SSDA Response to GANSW Letter dated 03/03/2021		
Comment	GroupGSA Response (on pages 85-86 of SSDA Report)	SSDA Report / drawing references
<b>Masterplanning</b>		
The design should be better integrated with the existing topography of the site. Demonstrate how the changes to the levels will allow for tree retention	<p>Site levels respond to the function of the building as an School for students with Special Needs which will be attended by students with special needs, many of whom are wheelchair users. Consequently the design has minimised falls across the play area with a gradient of 1:40 to the courtyard playground. This functional requirement has impacted the extent to which the existing site levels can be maintained. Adjustments following the first review with GANSW include:</p> <ul style="list-style-type: none"> <li>•Number of new trees increased</li> <li>•More existing trees retained around the Productive garden by introduction of low height retaining wall structures</li> </ul> <p>Presentation of the buildings and boundary treatment to the existing roads has been considered. Planting has been used to screen fences and soften level changes.</p> <p>Refer to Landscape section of

SITE PLAN

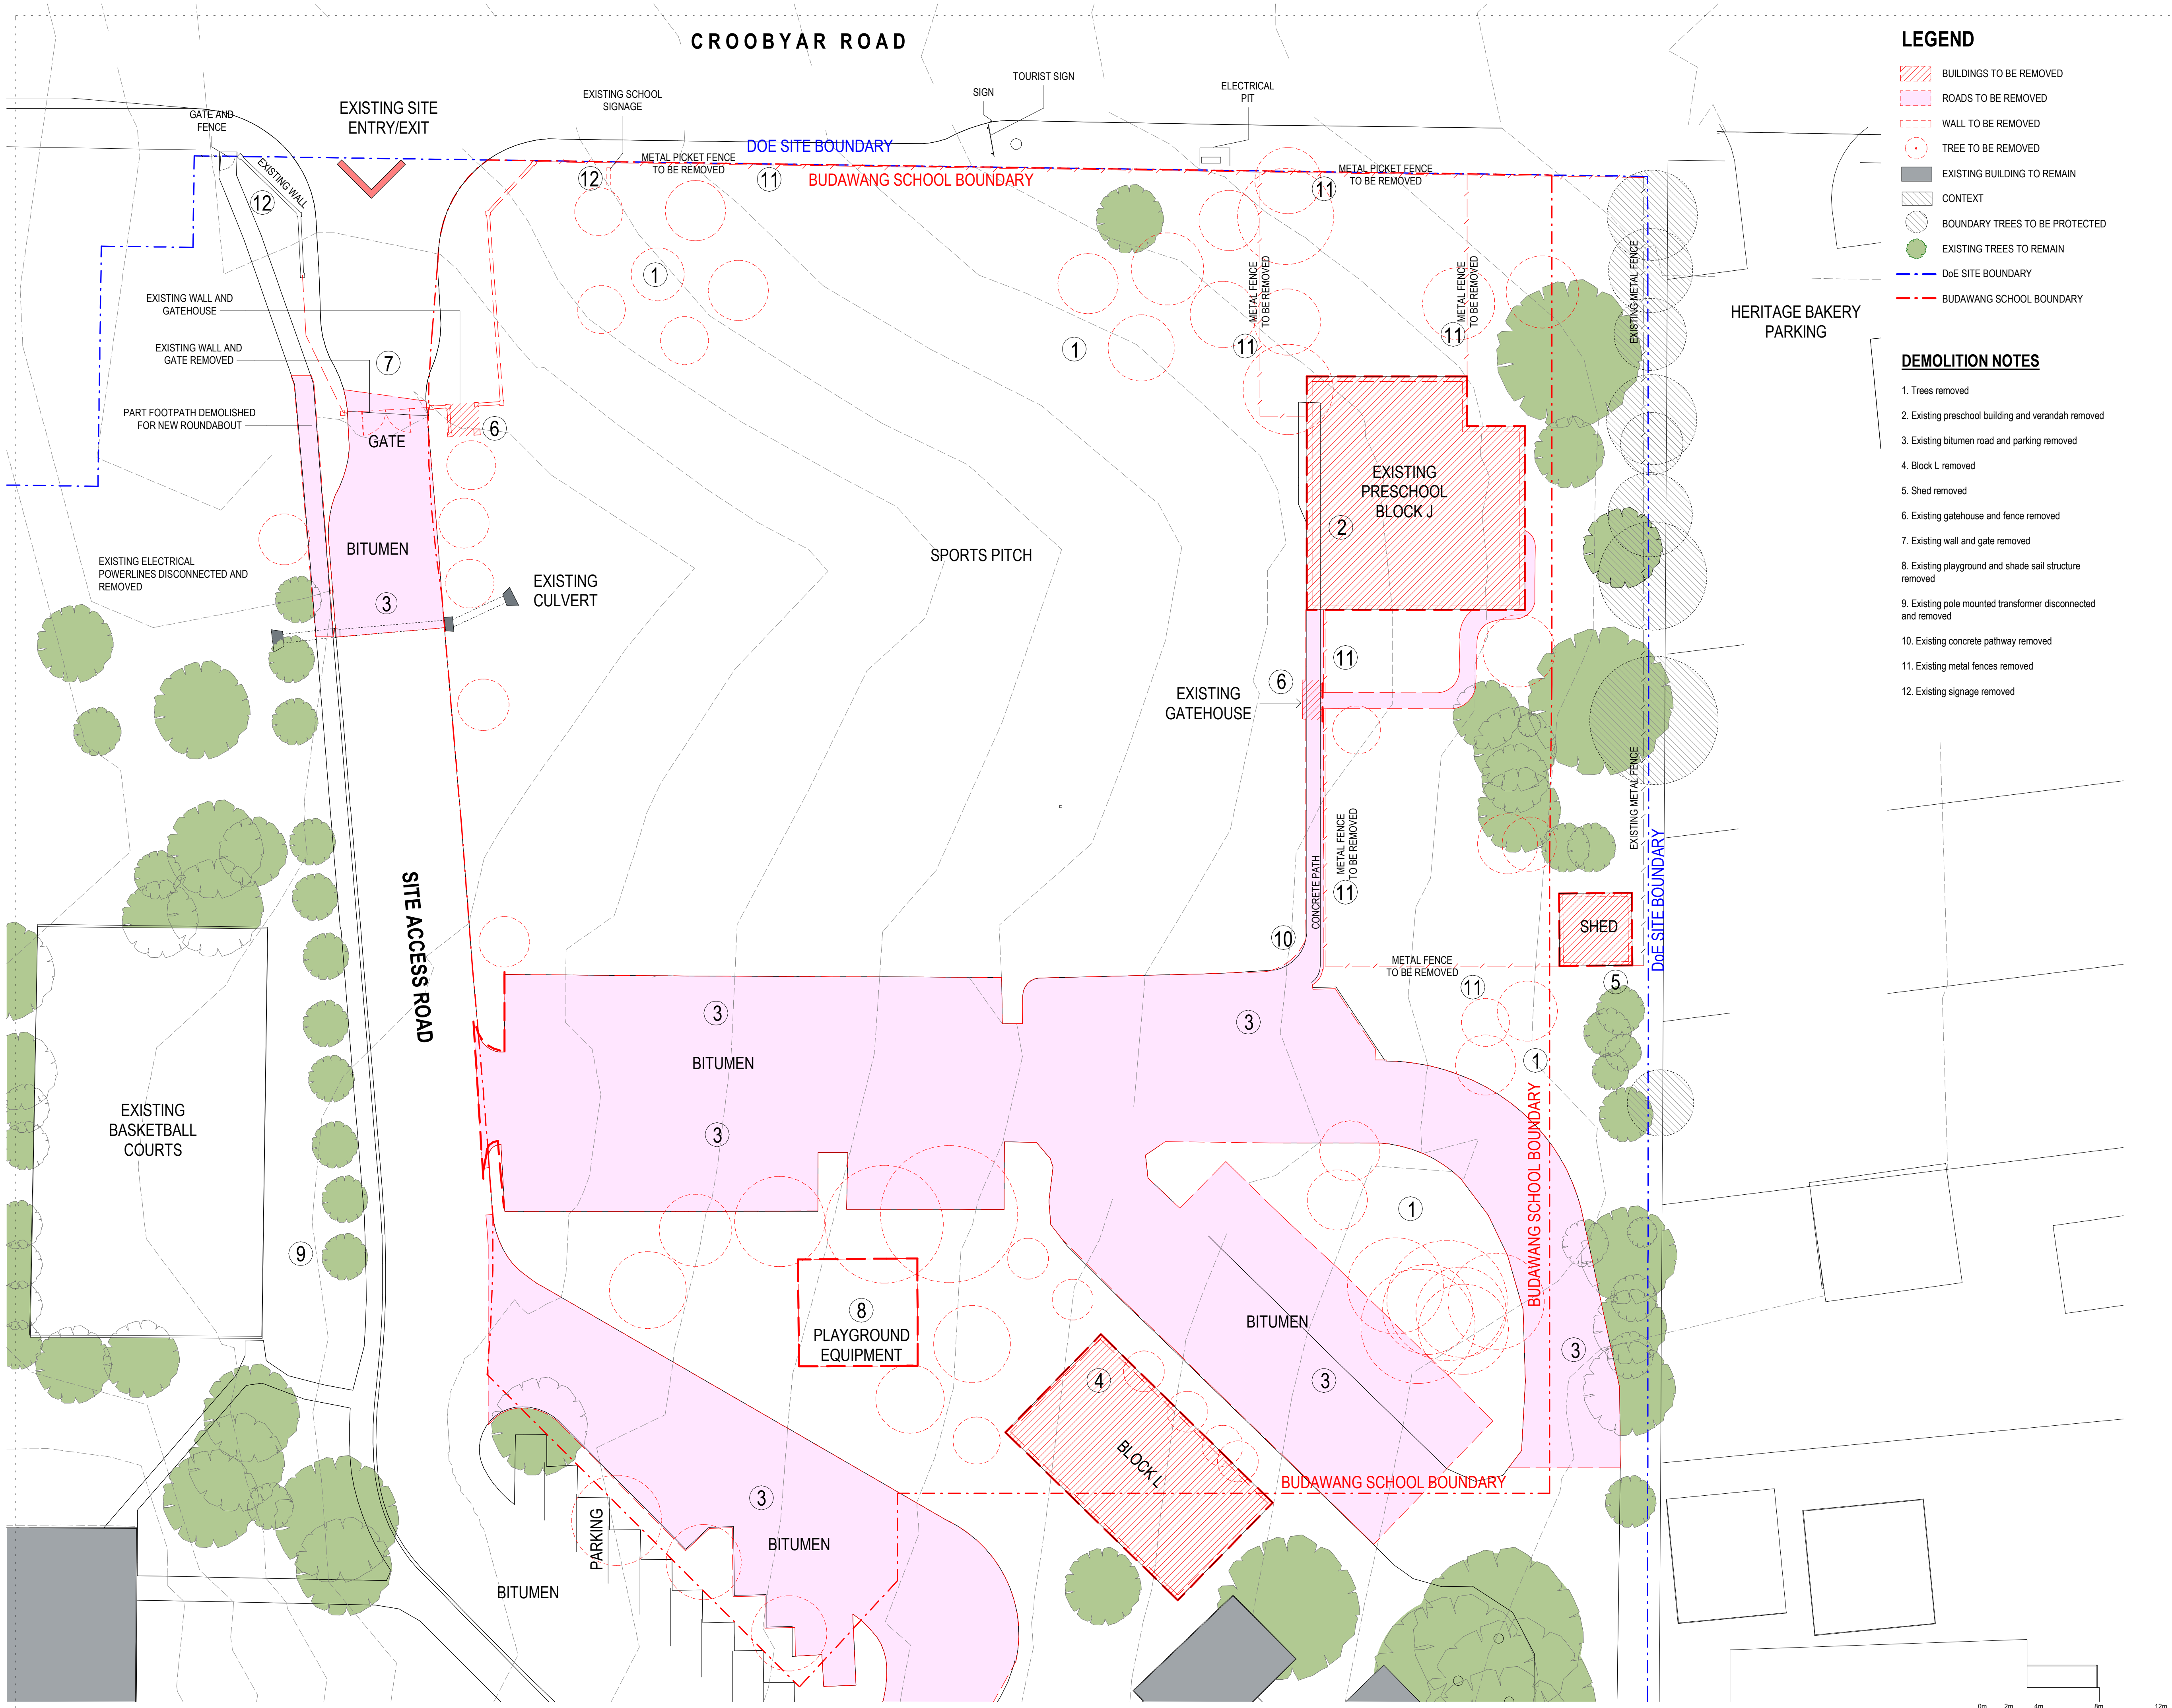
The edge condition to the east of the site and visibility into the homebases from the elevated pedestrian path requires further resolution	<p>The pathway to the eastern side of the Budawang School site lies outside the site boundary and does not form part of this application. Fencing has been selected to provide adequate privacy to and from the outdoor learning spaces located behind the homebases. Planting is also being use for screening to this fencing.</p> <p>Refer to Landscape section of SSDA Report for further information.</p>	<p>Refer to:</p> <ul style="list-style-type: none"> <li>- SSDA Report page 85 for response to GANSW</li> <li>- SSDA Report pages 61-62 for Fencing Strategy</li> </ul>
Community access to the Hydrotherapy Pool is supported. Provide a management plan indicating which facilities are accessible by the broader commuity and how these are accessed. More detail resolution is required to pedestrian access as well as drop off arrangement for the pool.	<p>Due to the disabilities of people attending the pool it is expected that people using the facility will arrive by either car or taxi. From the car park access to the Hydrotherapy Pool is via a footpath to a signposted entry.</p> <p>Footpath arrangements have been amended to improve access from the car park to the Pool.</p>	<p>Refer to:</p> <ul style="list-style-type: none"> <li>- SSDA Report page 85 for response to GANSW</li> <li>- Drawing SSDA-2000 for Site Plan</li> <li>- Drawings SSDA-2800 and SSDA-2801 for signage information</li> </ul>

The proposed scale of the car park and its proximity to the street do not deliver good urban design outcomes. Consider alternative options for car parking and access that allow the school and the hydrotherapy pool to have a public address to the street	<p>Buildings that create a public façade for the school also require adjacency with the car park for ease of access both during and outside school hours. Site constraints have resulted in the need to locate these core facilities and consequently the car park to the front of the site. To diminish any adverse visual impact of the car park on Croobyar Road the following changes to the plans are being implemented and can be viewed within the SSDA drawings:</p> <ul style="list-style-type: none"> <li>•Eight parking spaces removed from the car park to the front of the site and relocated to the site access road to the west and will be constructed if required in the future.</li> <li>•Twenty two new trees planted within the car park to replace those removed</li> <li>•Planting to the street boundary fencing to obscure views of the car park</li> <li>•Street frontage of Hydrotherapy building used as site boundary</li> <li>•Suggestion for Hydrotherapy street frontage to include a mural depicting local or indigenous themes.</li> <li>•Location of the car park is based on the functional relationship of pick up and drop off, combined with achieving a connection to other educational facilities within the wider DoE site.</li> <li>•Best use of available land, achieving Government value for money objectives.</li> </ul>	<p>Refer to:</p> <ul style="list-style-type: none"> <li>- SSDA Report page 85 for response to GANSW</li> <li>- Architectural Site Plan drawing SSDA-2000</li> <li>- Landscape Site Plan drawing L-2001</li> <li>- SSDA Report page 62 for boundary treatment information</li> </ul>

190941 SSDA-2012 D

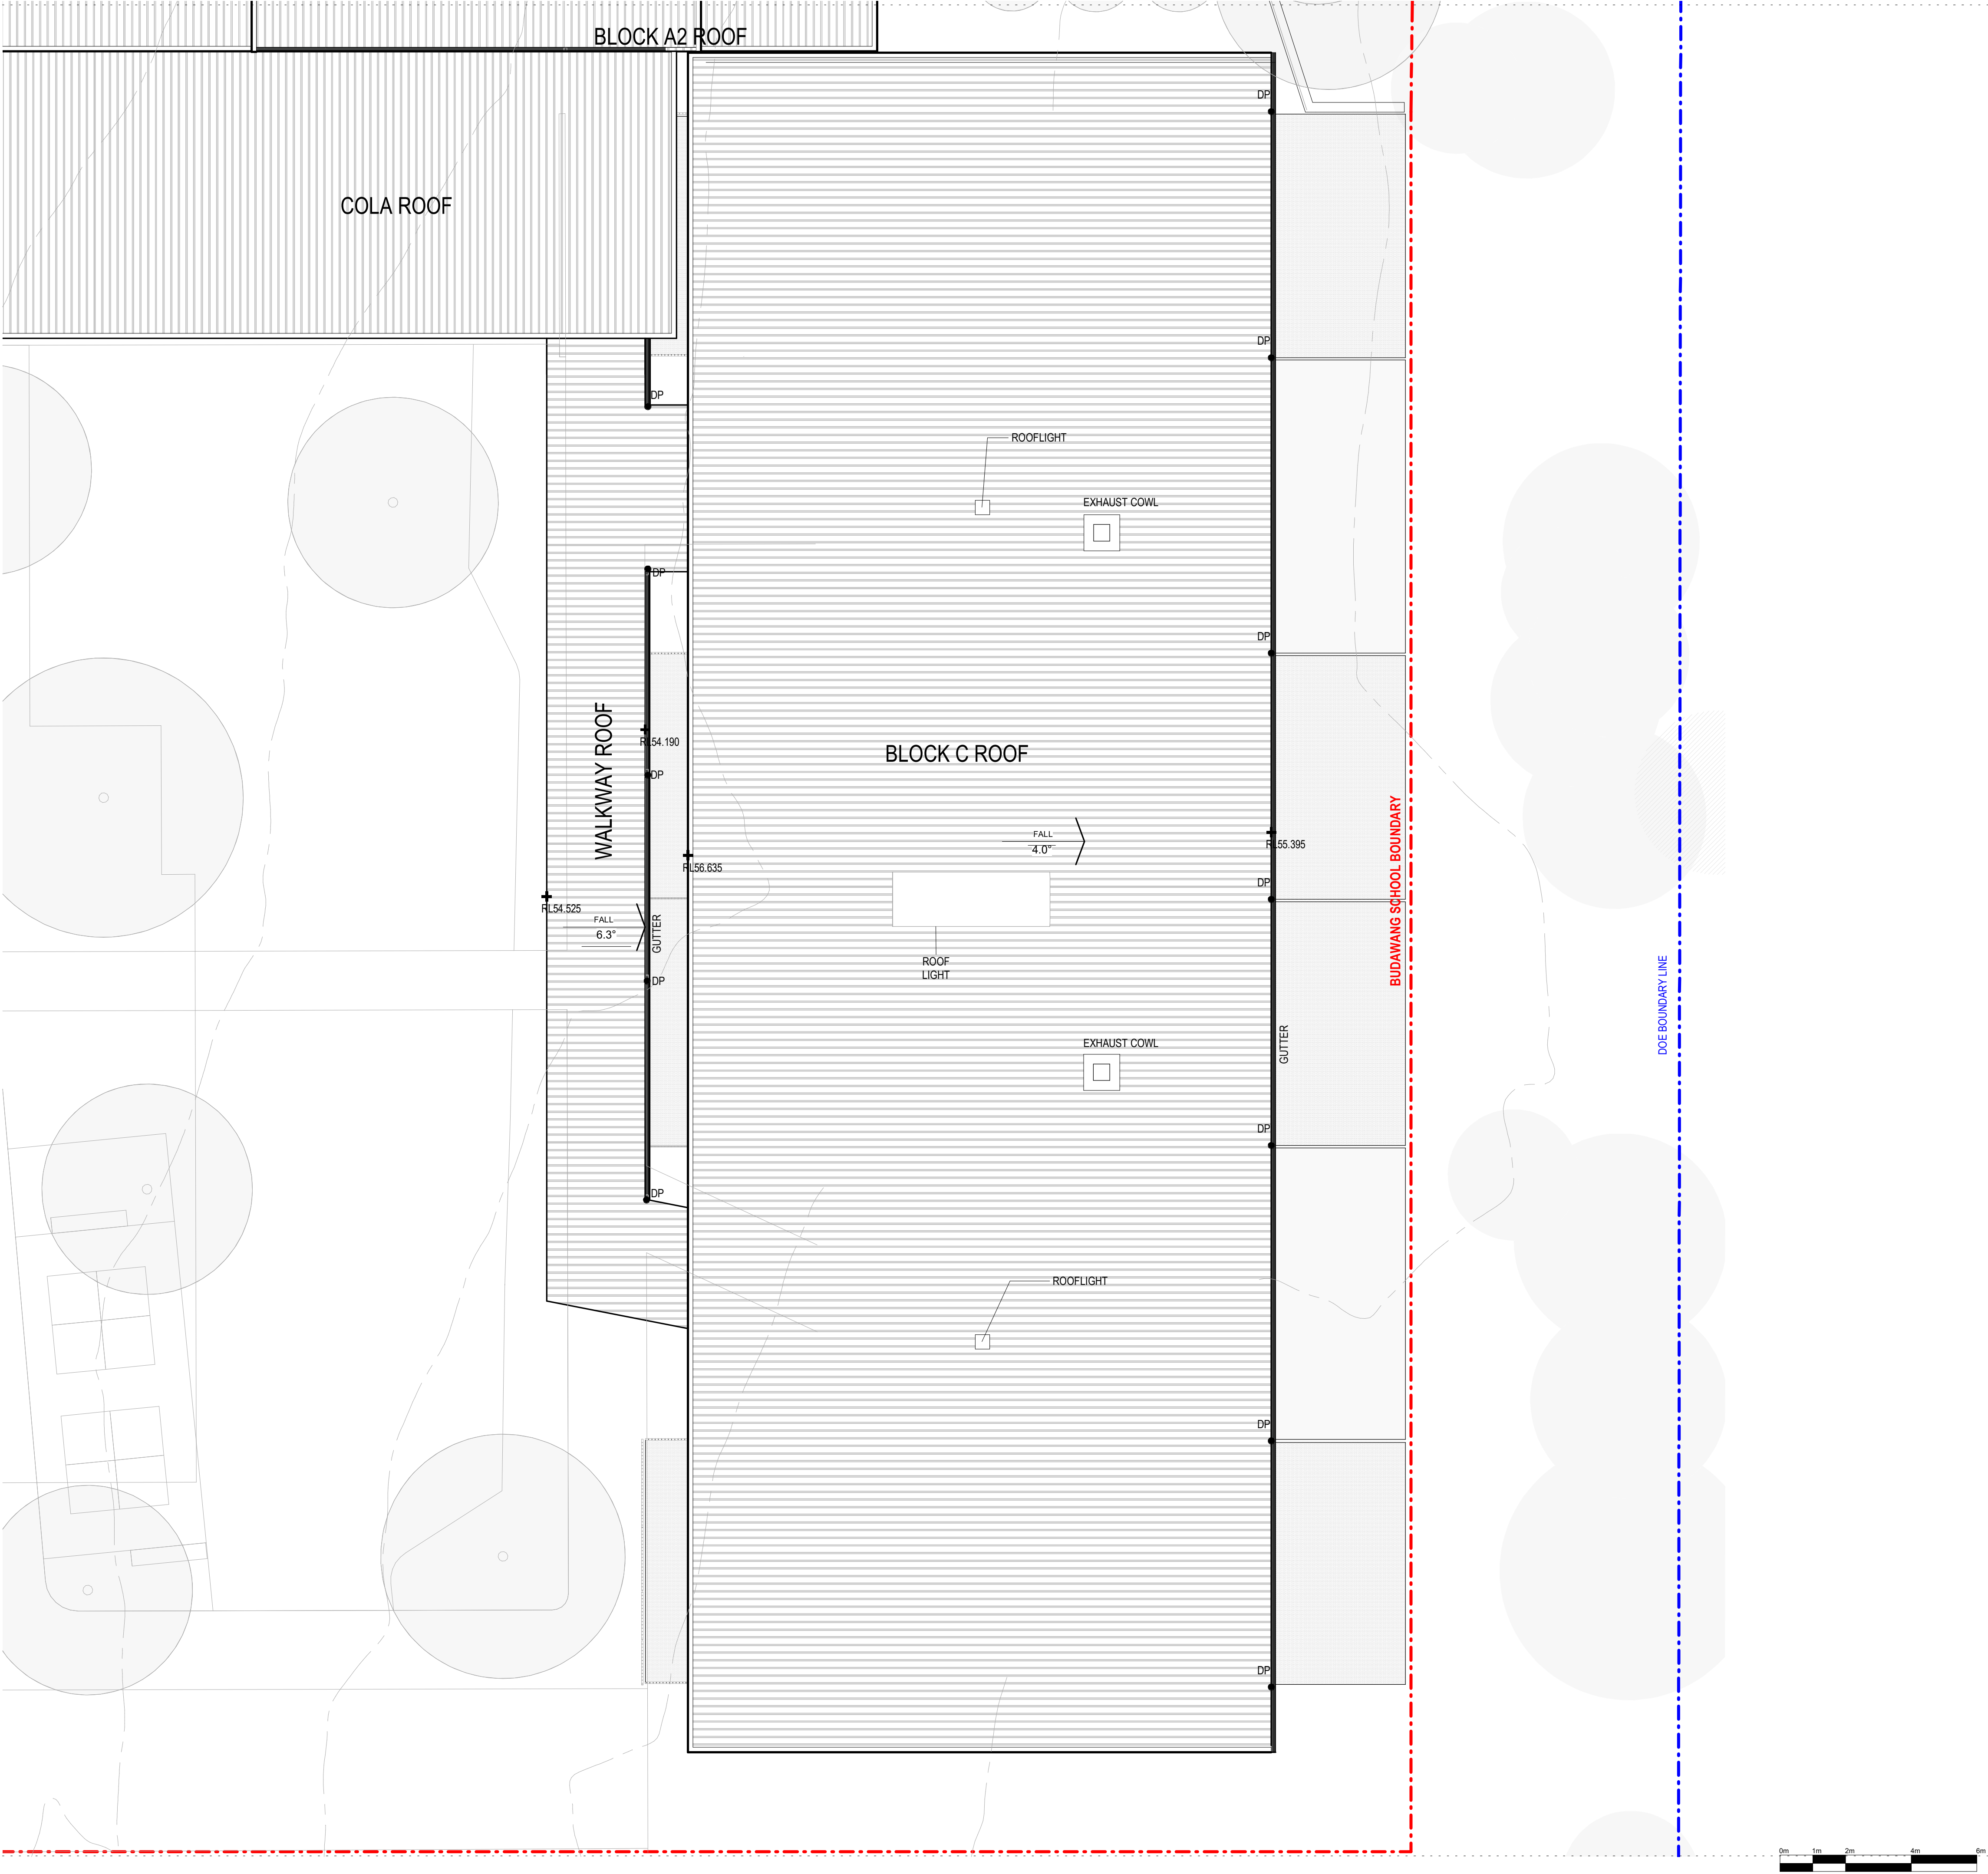
Provide more details on the thresholds of inside to outside and "pause spaces"	<p>Each function has an entry space. The size of these spaces reflect the primacy of the entry. The Homebase outdoor learning spaces and pause spaces associated with the homebase block entrys are illustrated in the SSDA Report.</p>	<p>Refer to:</p> <ul style="list-style-type: none"> <li>- SSDA Report page 86 for response to GANSW</li> <li>- SSDA Report page 42 for location of pause spaces</li> <li>- SSDA Report page 70 for pause spaces associated with homebase blocks</li> </ul>
The plenums to the homebases appear to be significantly oversized for the room volume. We understand the desire to create a feeling of differentiation in the space however this can be achieved in other ways which do not affect solar access and daylighting to these deep floor plates. The reduced ceiling heights to the withdrawal rooms will make tight enclosed spaces.	<p>The ceiling to the back of the homebases and Withdrawal Rooms is 2700mm high. Ceiling height to the front of the homebases is around 4200mm. This is to create a variety of different scales of space.</p> <p>Withdrawal rooms are used within Schools for Students with Special Needs to decompress and calm; these are not intended to be large spaces.</p> <p>Rooflights have been included within the homebases to allow daylight into the centre of the homebases.</p>	<p>Refer to:</p> <ul style="list-style-type: none"> <li>- SSDA Report page 86 for response to GANSW</li> <li>- Architectural drawings SSDA-3111 and SSDA3112 for sections through homebases</li> <li>- Architectural drawings SSDA-2012 and SSDA-2013 for position of homebase rooflights</li> </ul>
